Application for Planning Permission for Works or Extension to a Dwelling

Development: Proposed single storey rear extension, New pitched roof to front dormer to replace existing flat roof, New carport timber canopy and new boundary wall to front elevation.
Location: 3 Meadow Way Aldwick PO21 4HG

PROJECT		Proposed single storey rear extension & new pitched roof dormer 3 Meadow Way Bognor Regis Aldwick w.Sussex PO21 4HG	
TITLE		Existing and Proposed Roof Plans	
CLIENT		Mr Alan Chiverton	
SCALE	1: 100 at A3 paper size	DATE	29/07/2026
DRAWING NO.	1280-03	rev.	17/08/2026

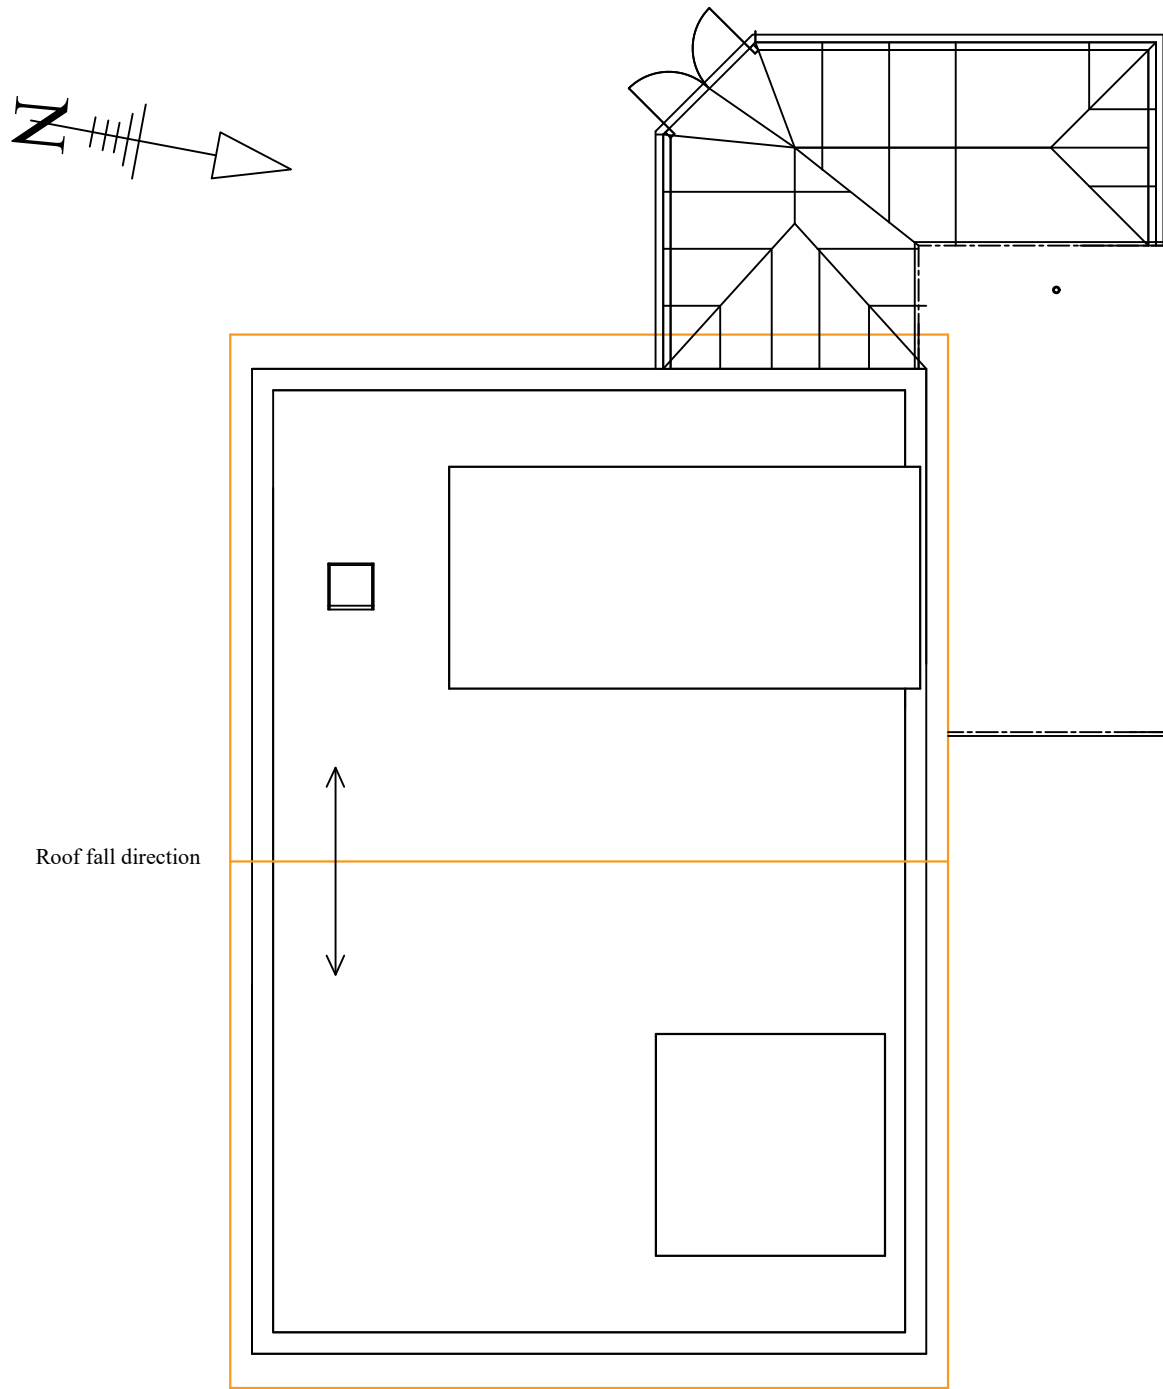
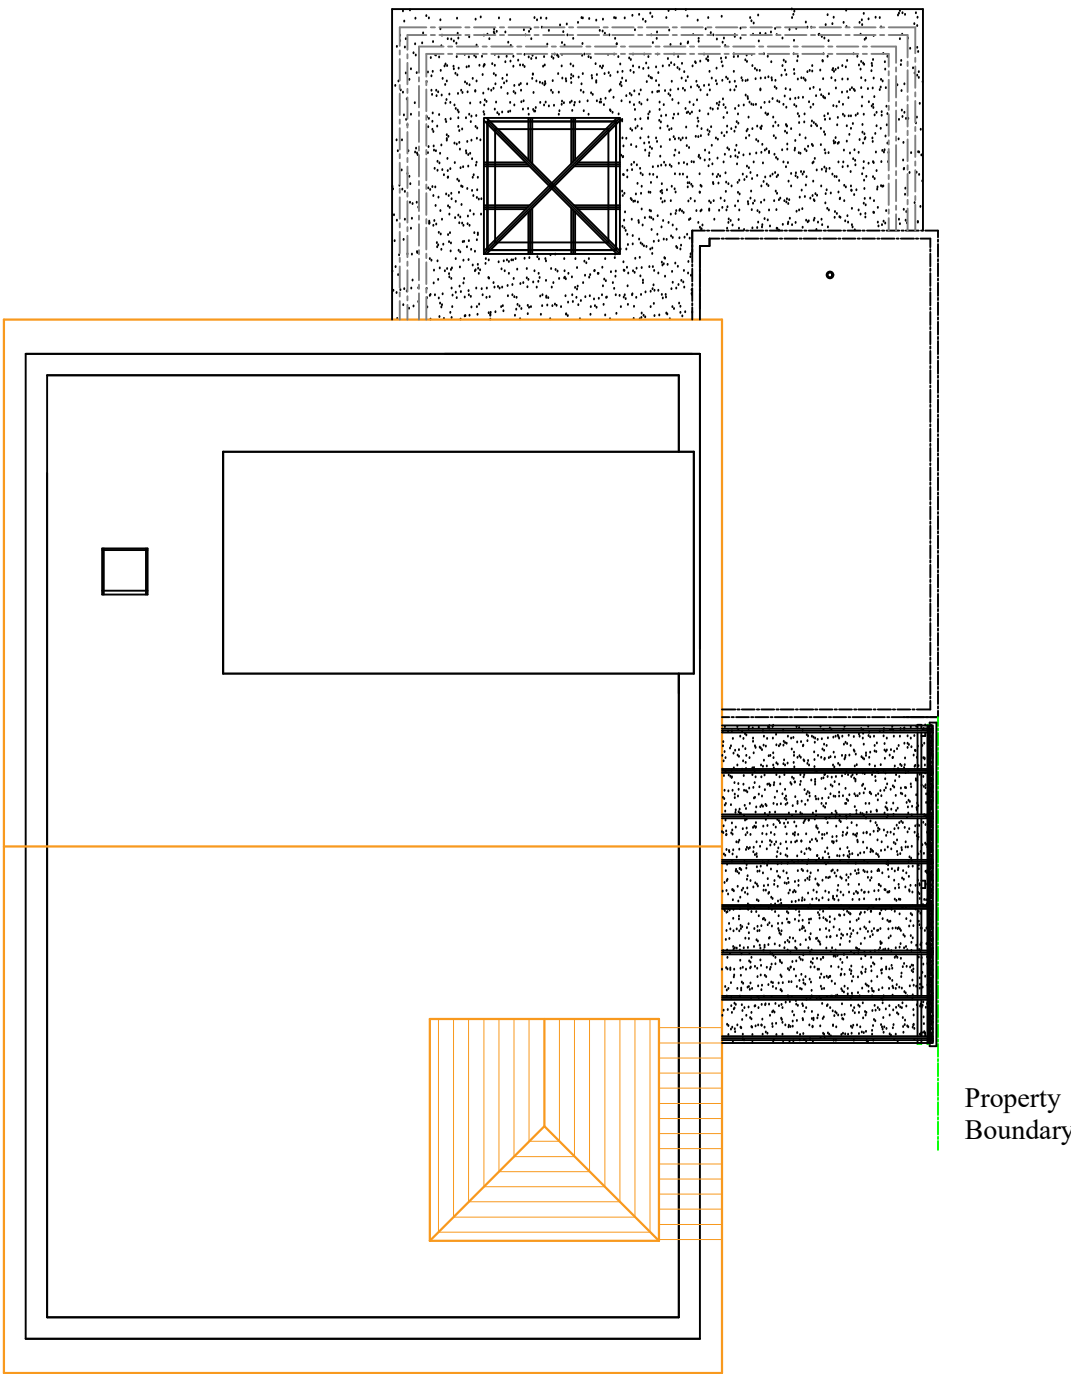
The dormer can be hatched however the main roof cannot as this suggests new roofing being part of the works which is not mentioned in the description.

Please clarify what is shown on the proposed first floor plan and roof plans that appears to be a form of hardstanding or roof on the side of the garage. Please review and amend so that the related plans are consistent.
